THE RESERVE AT CORRAL BLUFFS FILING NO. 4

A VACATION AND REPLAT OF TRACT A, THE RESERVE OF CORRAL BLUFFS FILING NO. 3
 A PORTION OF THE EAST HALF OF SECTION 31 AND WEST HALF OF SECTION 32
 TOWNSHIP 13 SOUTH, RANGE 64 WEST OF THE 6TH P.M.
 EL PASO COUNTY, COLORADO

Final Plat_V1.pdf Markup Summary

THE RESERVE AT CORRAL BLUFFS FILING NO. 4

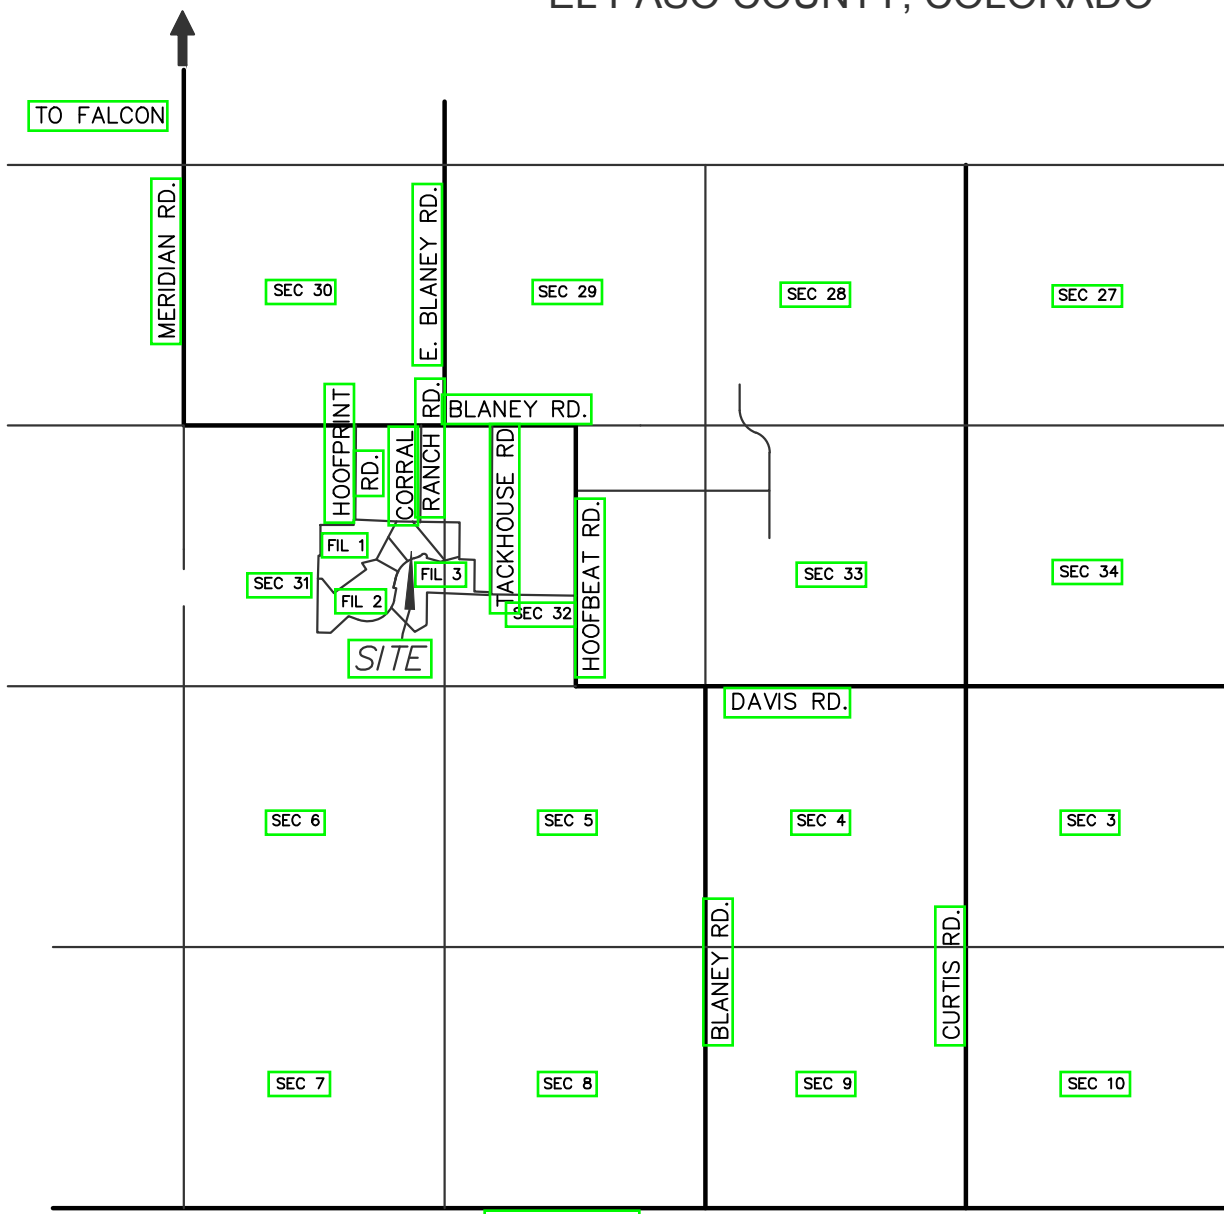
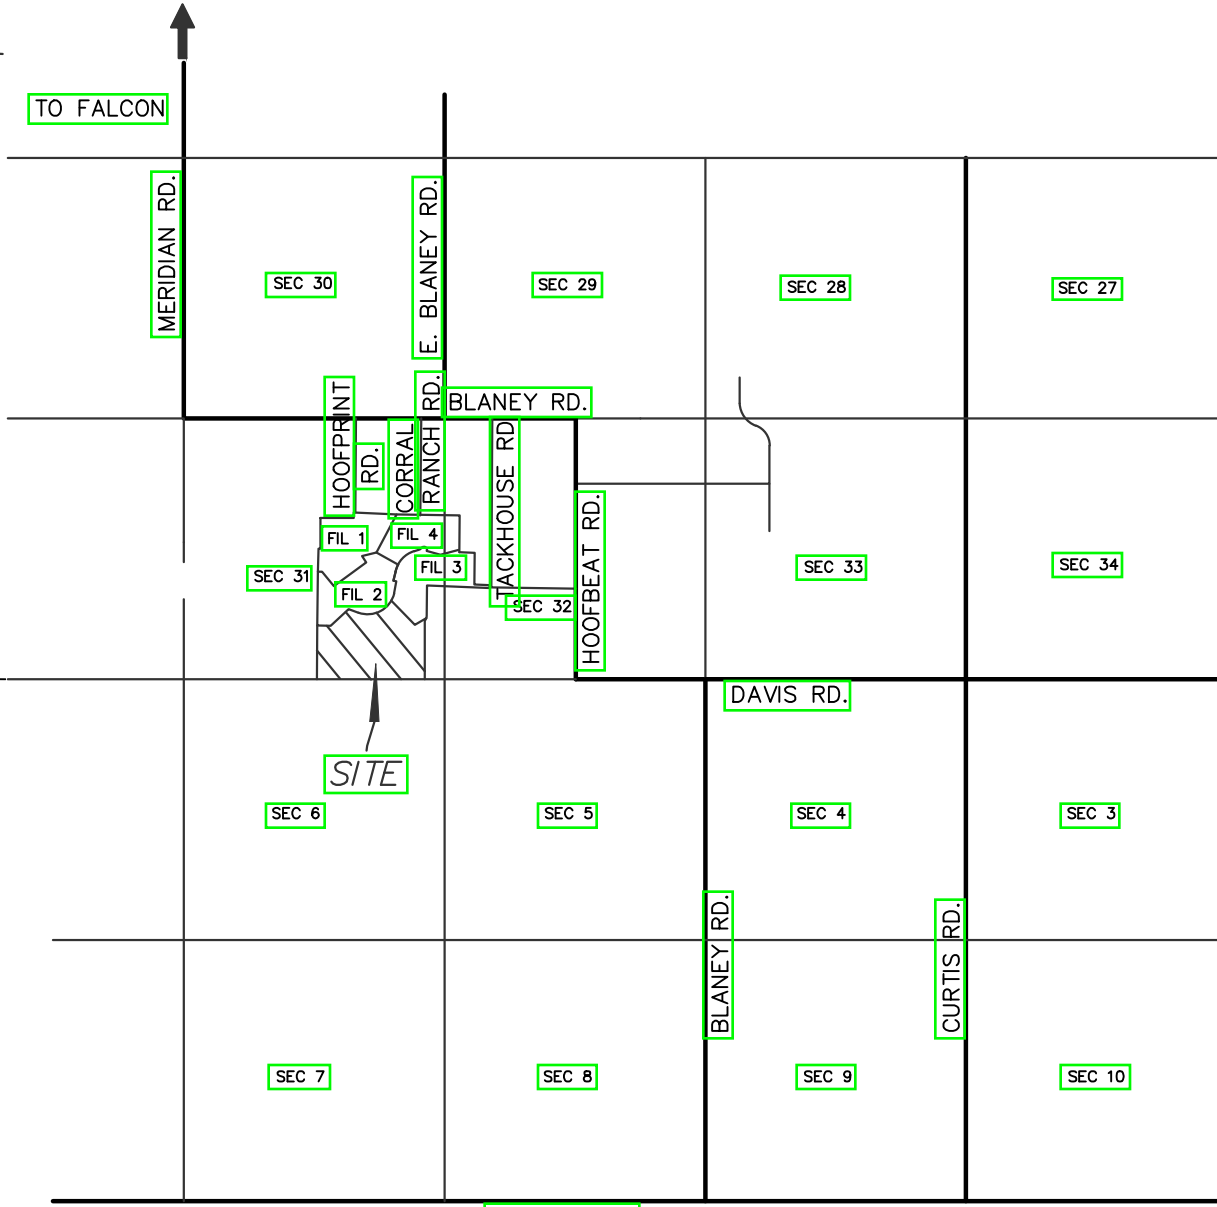
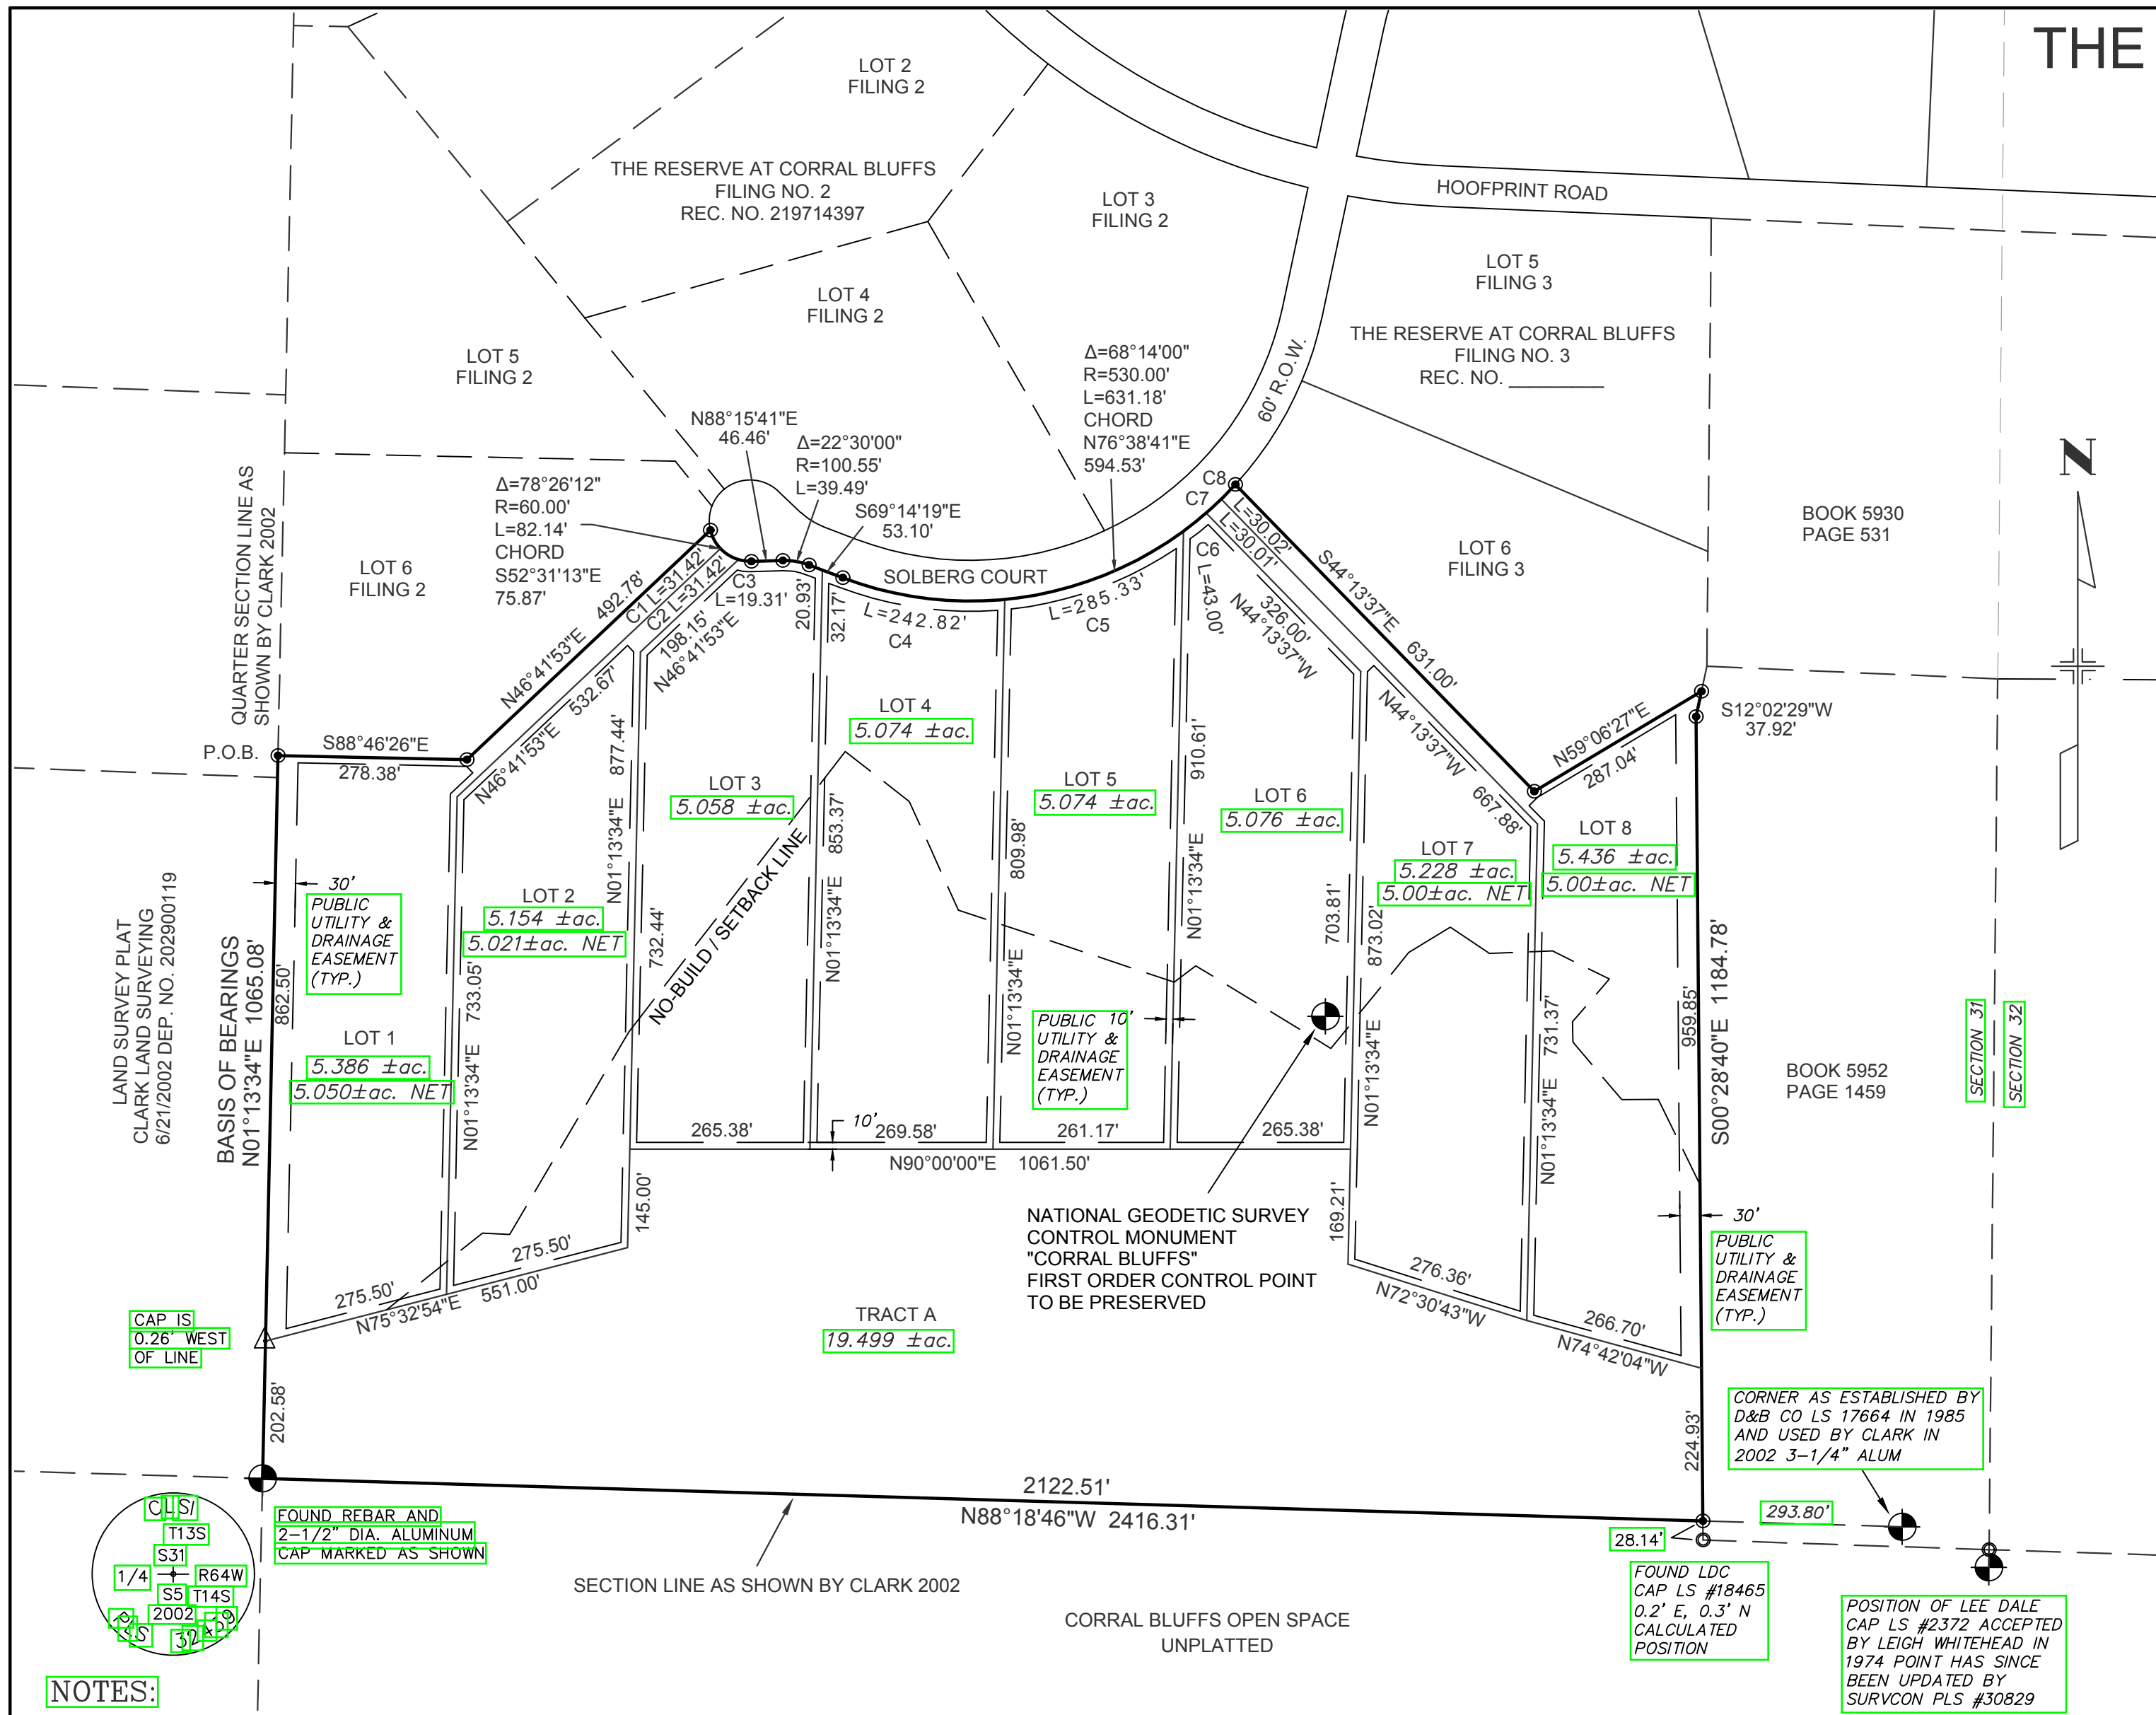
Revise the easement to include public improvements as shown on the road section in the construction documents of Filing 3.
 Unresolved. Provide a 5' public improvement easement per the standard EPC rural gravel road section (detail SD_2-10)

Add the following plat note:
 Lot 4 of this property is subject to a Private Detention Basin/Stormwater Quality BMP Maintenance Agreement and Easement as recorded at Reception No. _____ of the records of El Paso County. The _____ HOA (or Owner or District) is responsible for maintenance of the subject drainage facilities.

Previous comment not addressed - verify information, soils and geology report indicate impacts to Lot 4, and areas of ponding water should be no-build areas and should be depicted

Lot 4 is shown to have issues in Soils and Geology Report but not identified, areas of ponding water should have no build area on plat

Note 1 should be about why you are vacating and replatting. ie. The parcel was platted as a tract in previous filing to not create an illegal parcel, being vacated and replatted for this filing for future development or similar language.
